Technical Note 1: Highways

Project: Britannia Mills, Slaithwaite,
West Yorkshire

15 June 2018

This Technical Note has been written in response to the consultation comments dated 22nd February 2018 made by Kirklees Metropolitan Council's (KMC) Highways Officers on planning application reference 2018 / 90051. The document is not annotated on every page but does have some headings on the three pages. Reference is therefore made to the pages (1 to 3 in the PDF document) and the headings used as appropriate. The said document is attached to this Technical Note.

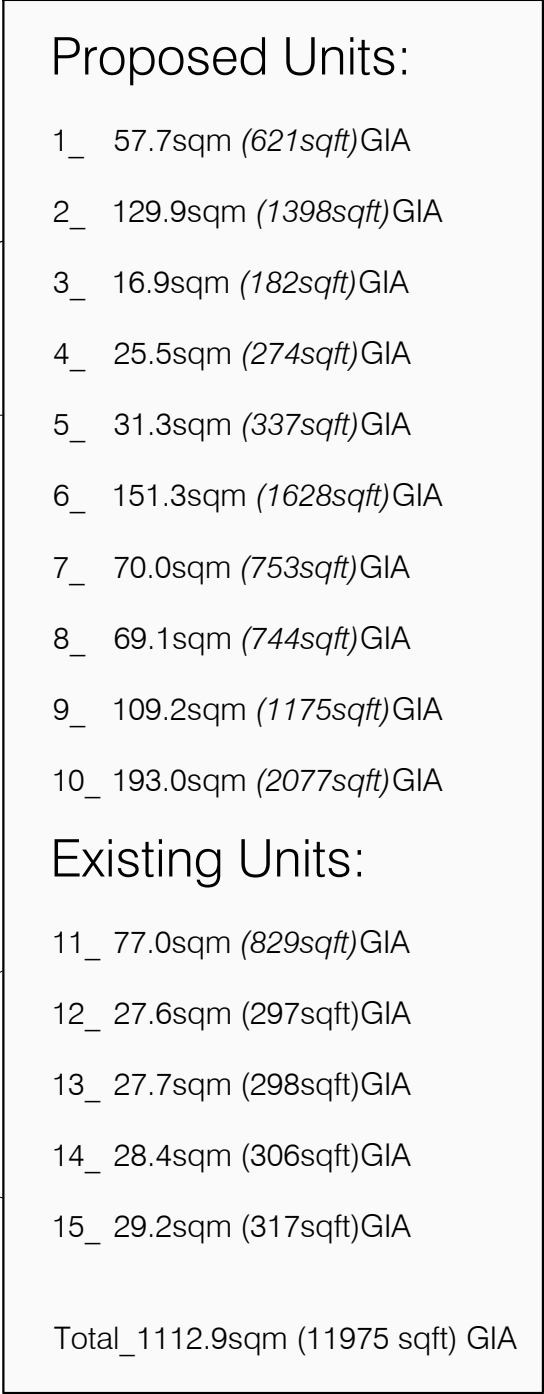
The original proposals were for 22 spaces which complies with the parking guidance for the proposed development. However, KMC has asked for provision to be made for the existing / retained uses adjacent to the proposals.

The revised swept path analyses have also shown that we can adjust the position of some of the new parking spaces slightly which would allow a further 4 spaces to be provided behind them (in tandem), an extra 4 spaces on the eastern boundary and 2 spaces (in tandem) towards the southern (Kiln Hill) boundary.

Therefore, there are 7 spaces shown out with the development site for existing retained uses adjacent to it plus 32 spaces (29 if the tandem spaces are excluded) within the development site for use by all occupiers of the existing and proposed development site.

DRAWING NUMBER: 1714101a

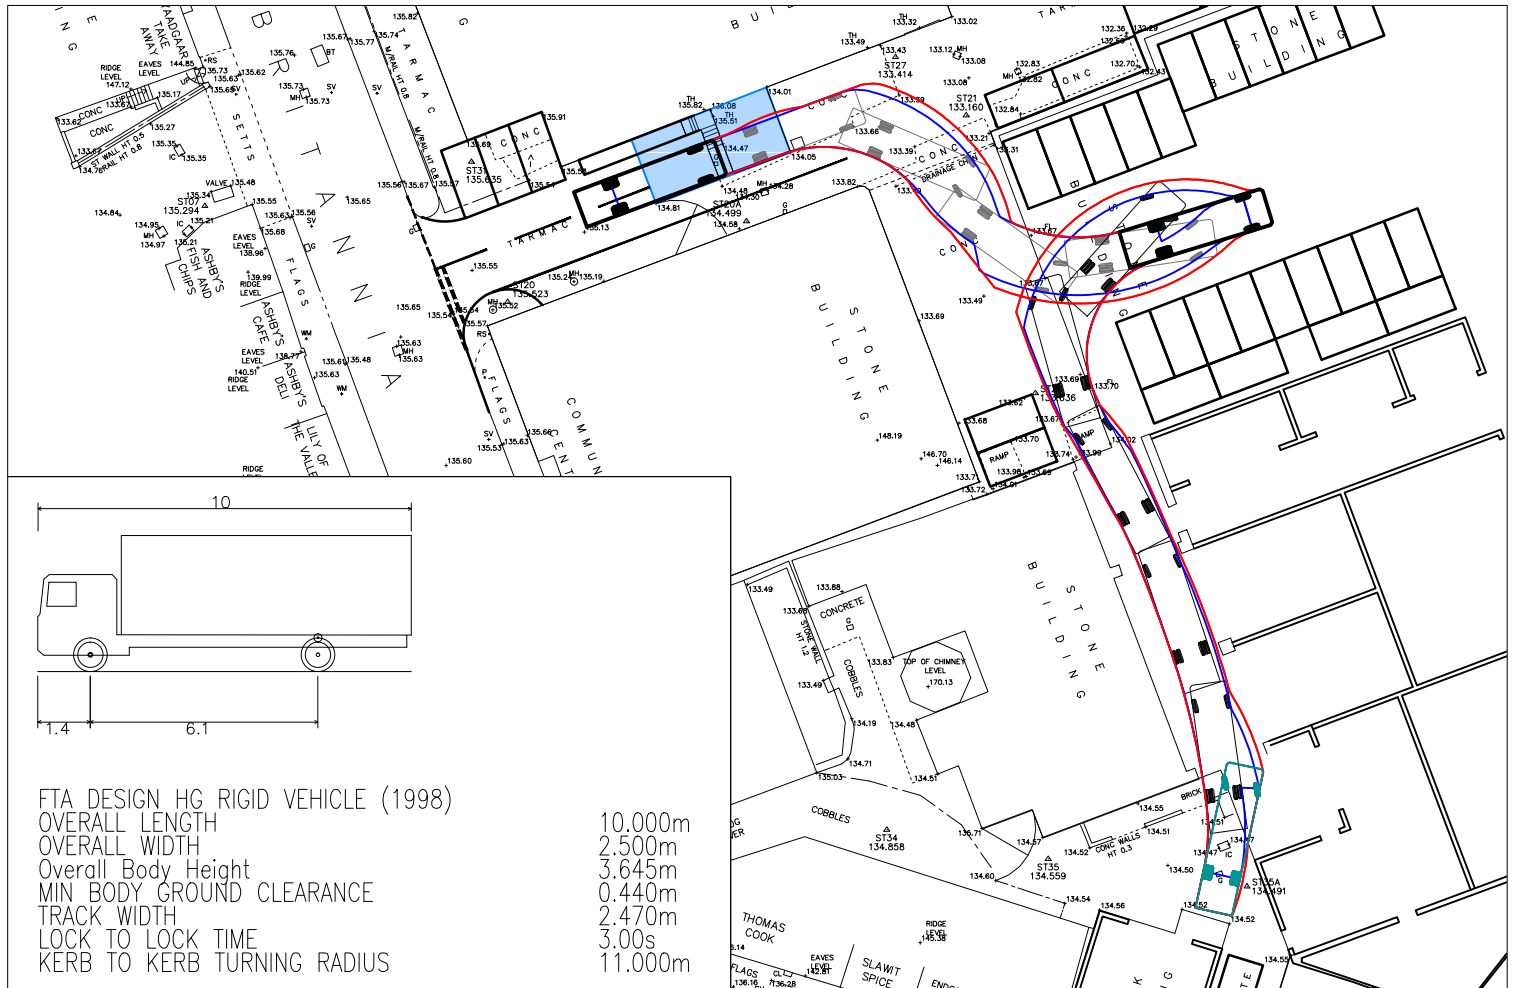
KMC Highways Officers comment that the existing access is narrow and there is not enough width for two vehicles to pass. Also state there is no pedestrian provision in to the site and the sight lines to the left when exiting the site are poor as is the inter visibility between drivers and pedestrians at the Britannia Road junction. KMC comment on the swept paths of vehicles turning in and out of the site and internally and that the proposed parking provision only refers to the proposed units. KMC question the predicted traffic for the proposed development in our Transport Statement (consider it to be low). Mention is also made of a previous approval for a major access improvement on to Britannia Road which would necessitate demolition of several buildings (single and multiple storey) and draw the above together in their conclusion suggesting access improvements, consideration of an alternate access on to Kiln Hill and parking for existing uses but do recognise the proposals do offer an improvement when compared to the existing situation.

The swept path analyses have been reviewed and repeated to assess where additional parking might be provided within the site. These are shown on drawings 1714101a, 1714102a and 1714103a attached to this Technical Note. These analyses show how differing sizes of goods vehicles can enter and leave the site and that there is some margin for driver error / variance in doing so. Vehicles up to and including 10m rigid vehicles can access all the site although given the size of many of the units, smaller vehicles are more likely to be used. Certainly that is the case with the occupiers of the existing retained units adjacent to the development site.

BRITANNIA MILLS
PROPOSED SITE ACCESS

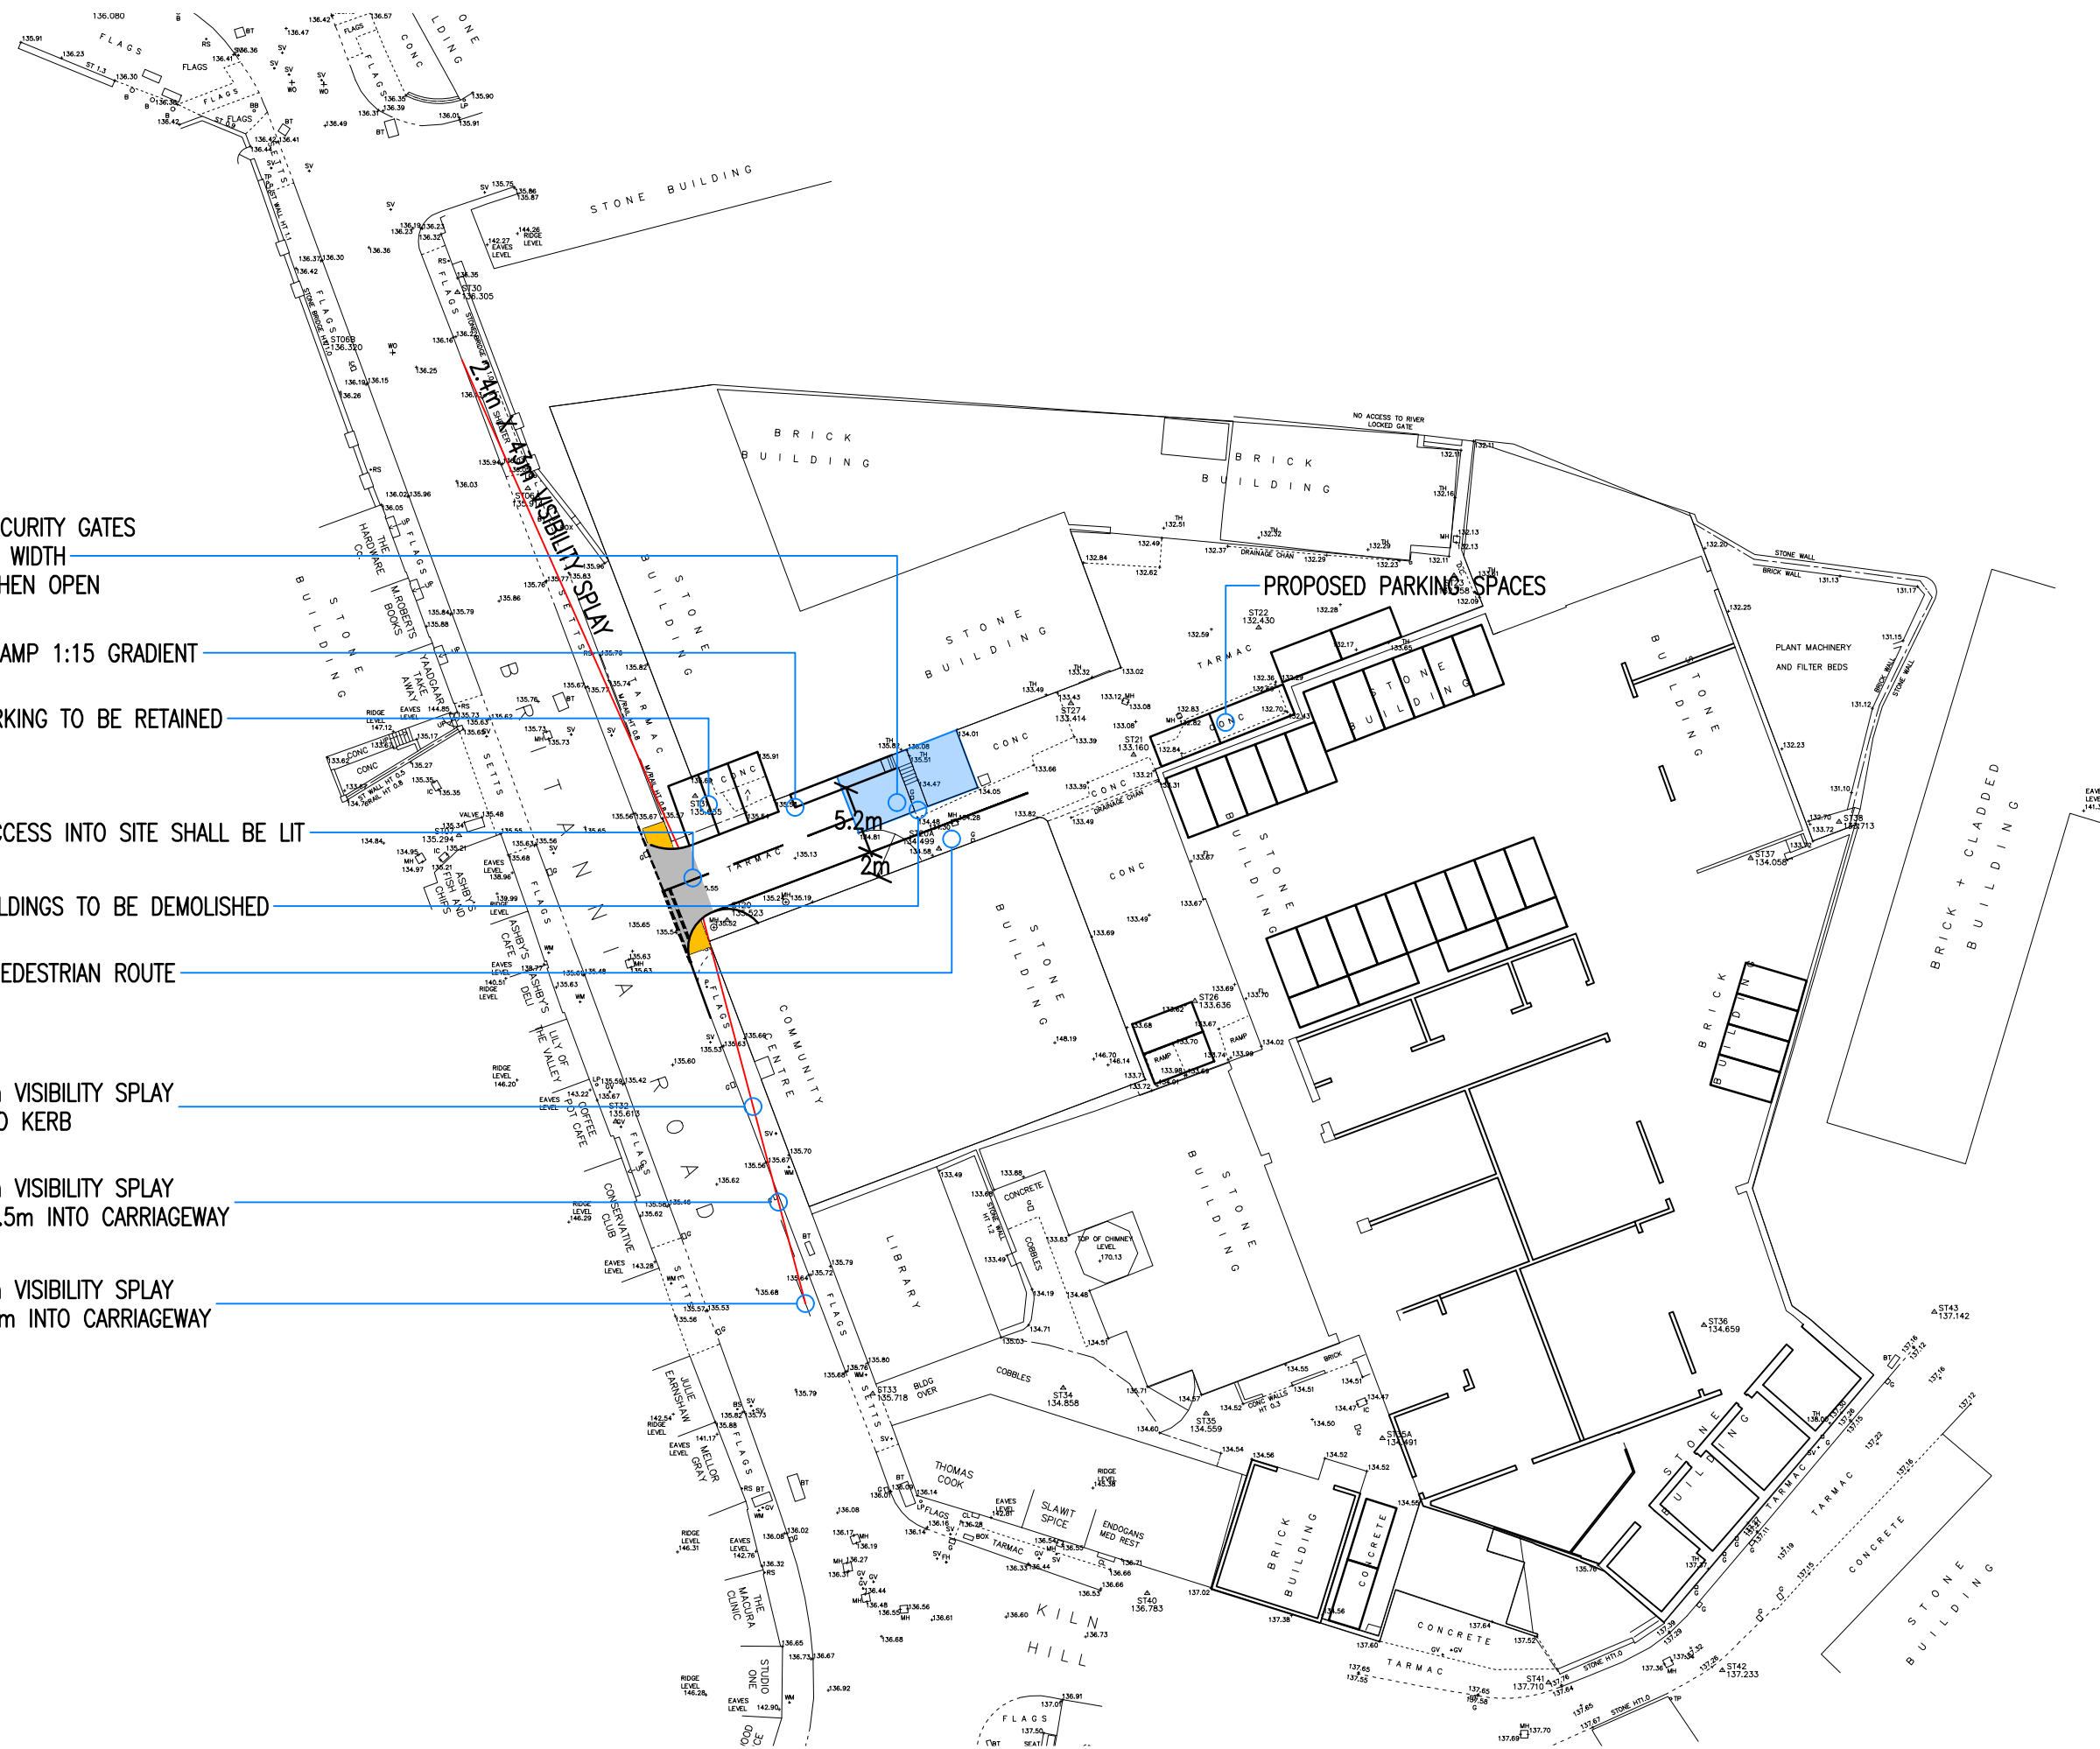
We have reviewed the large-scale access improvements referred to by the Officer and consider that a compromise solution akin the first stage proposals would be more appropriate having due regard to cost implications and viability of the development proposals.

A revised access proposal is now shown on drawing 1714104 attached to this Technical Note. This will require the demolition of a single storey building and the creation of a pedestrian ramp to provide access to the retained multiple storey building. The scheme would retain the three parking spaces close to Britannia Road and provide a radius build out opposite to push exiting vehicles away from the corner of the property to the south. The latter assists in maximising the visibility to the left (south) and driver / pedestrian inter visibility. A pedestrian route along the southern side of the access is also shown / would be marked out on site given the light vehicle flows using a widened access (5.2m).

Swept path analysis of the improved access shows that the anticipated sizes of vehicles can use it safely and it will represent a significant improvement on the existing situation.
